Your Ref: OWPC15323
Our Ref: AW/208/17/HH
Please ask for:
Mr R Temple

24th August 2017

Single storey front extension as annex for elderly relative
31 Queens Fields West Aldwick

Proposed Elevations

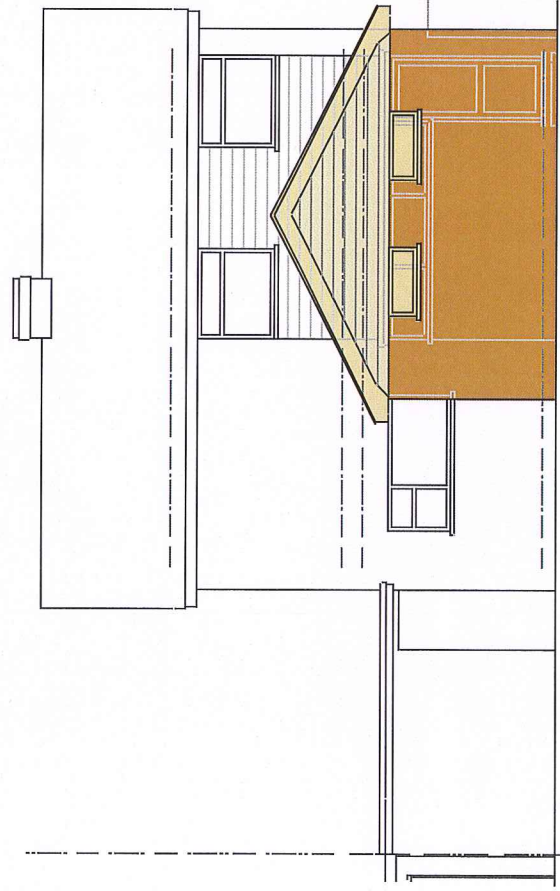
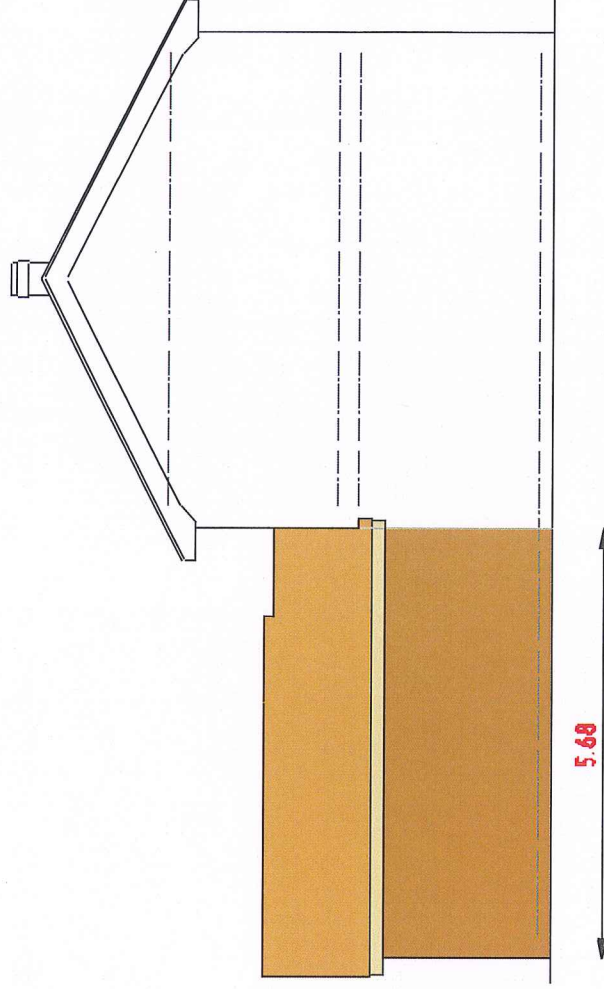
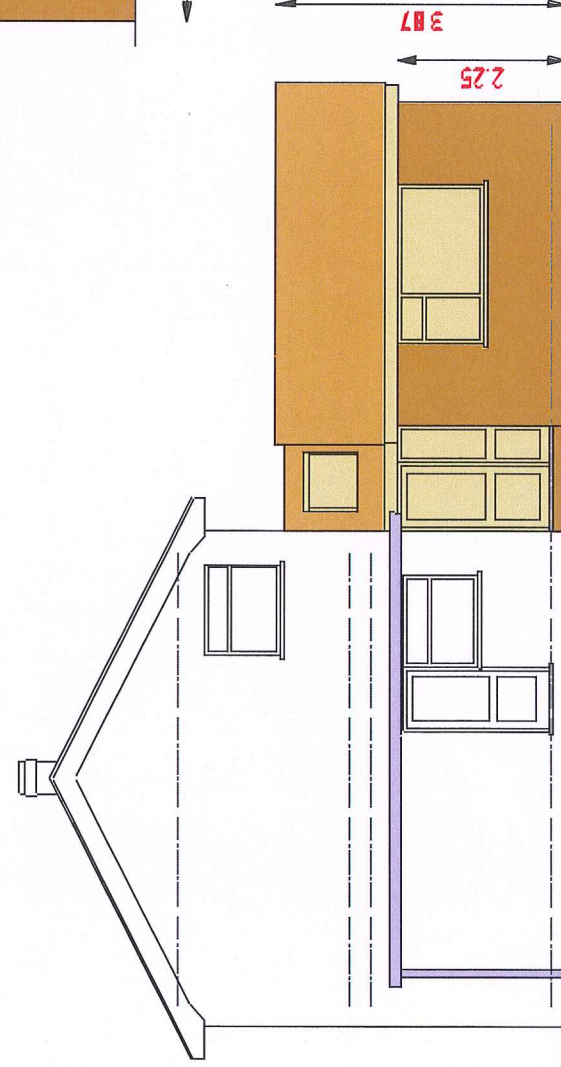
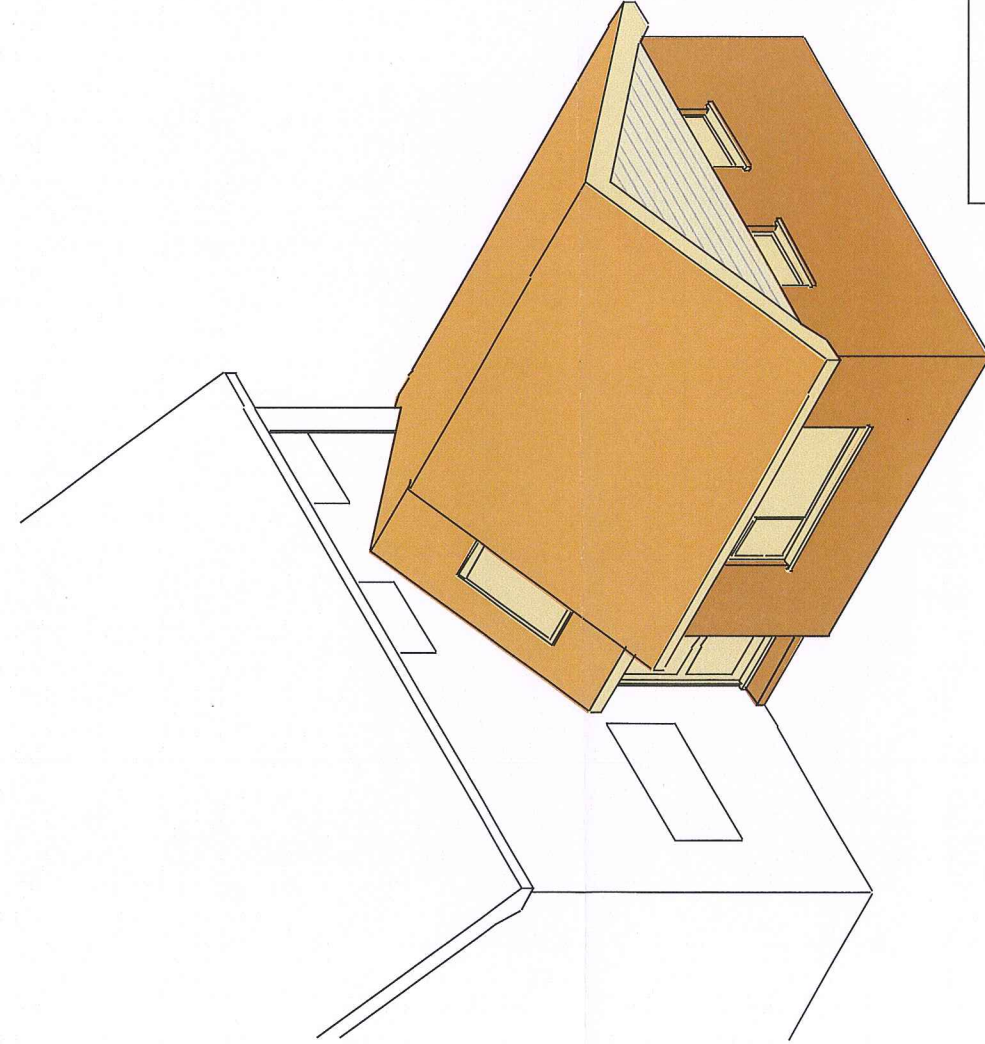
Members strongly opposed the application on the grounds that the Proposed extension does not sympathetically relate to and is not visually integrated with the existing building in siting, design form scale and materials and because the extension would not be visually subservient to the main building and because the extension would compromise the established spatial character and pattern of the street. Therefore, Members considered that the application is in direct conflict with Policy Dev 19 of the Arun District Local Plan (2003) and with the Parish Design Statement Development Criteria (page 71)
